Please upload onto Ocella the email below and the revised plans (attached) for **Condition 8** of Discharge of Condition application **Y/131/20/DOC** for Land South of Ford Lane and East of North End Road, Yapton.

- Drawing No. ITB14679-GA-002 Rev H – Public Right of Way Plan
- Drawing No. A855 84 Rev C – Movement Plan

The amendments are presented on Drawing ITB14679-GA-002 Rev H, & A855 84 Rev C attached.

Movement Plan

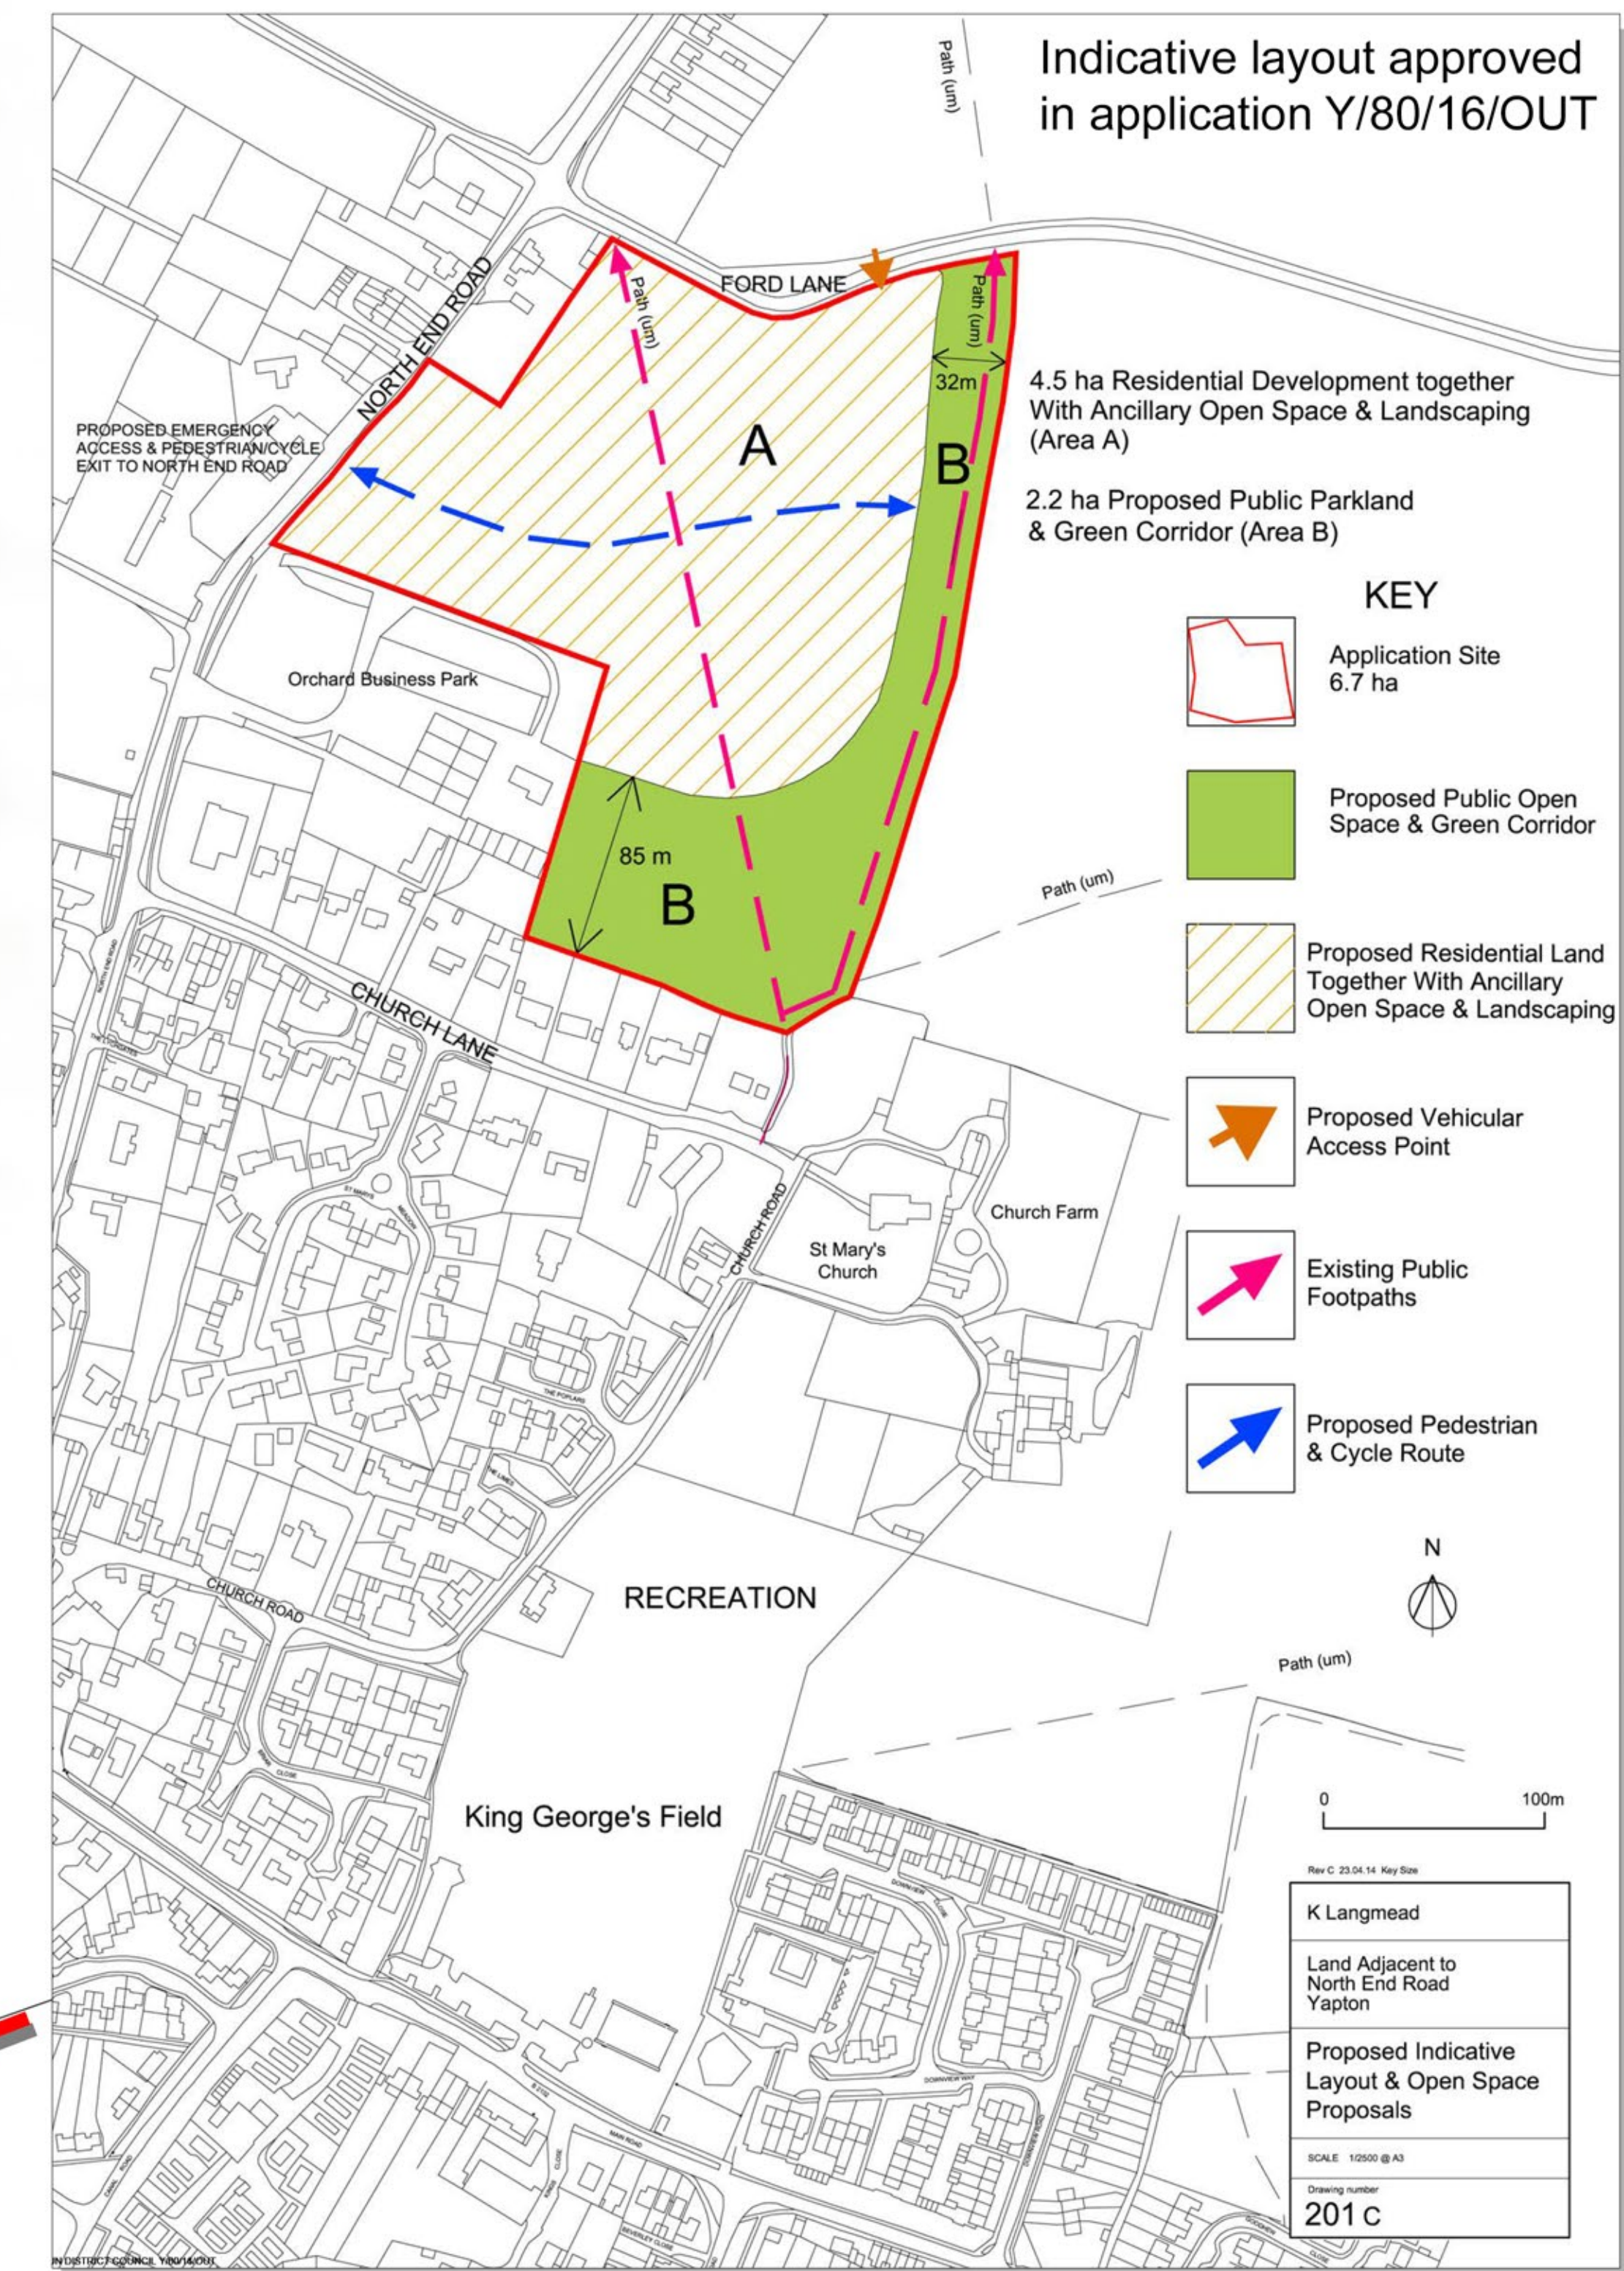
Further to our correspondence and your email dated 4th May 2021, we have reviewed the opportunity to provide an alternative alignment for the cycle route through the site. As requested, this is to provide a route to the eastern boundary of the site on the route shown in orange as opposed to the route shown in blue as outlined in the image below:

- The cycle link that was previously shown on the eastern boundary at a central position has been removed;
- Directional signage for cyclists identified at key locations to bring them onto the route;
- The tactile paving has been replaced with corduroy paving to denote shared use cycle/ped route at appropriate sections along the route; and
- Some additional corduroy has been introduced at the confluence of the PROWs at the south of the state to establish what is pedestrian only and pedestrian/cycle routes.

Therefore, the east-west section of the route between the cycle access onto North End Road and the existing Public Right of Way is to be retained on the carriageway. Creating a shared space cycle route adjacent to the carriageway along this section, with both pedestrians and vehicles emerging from the adjacent properties, would unnecessarily create an opportunity for conflict where the LTN guidance directs such journeys to be accommodated on road. The route then transitions to public rights of way that are currently of a 'Footpath' classification only. It is understood that it will be necessary for the status of these routes to be upgraded to allow for cycling, and that this will need to be subject of a formal dedication order with WSCC (e.g. the use of the Cycle Tracks Act 1984 or creation of a Bridleway through Section 25 of the Highways Act 1980).
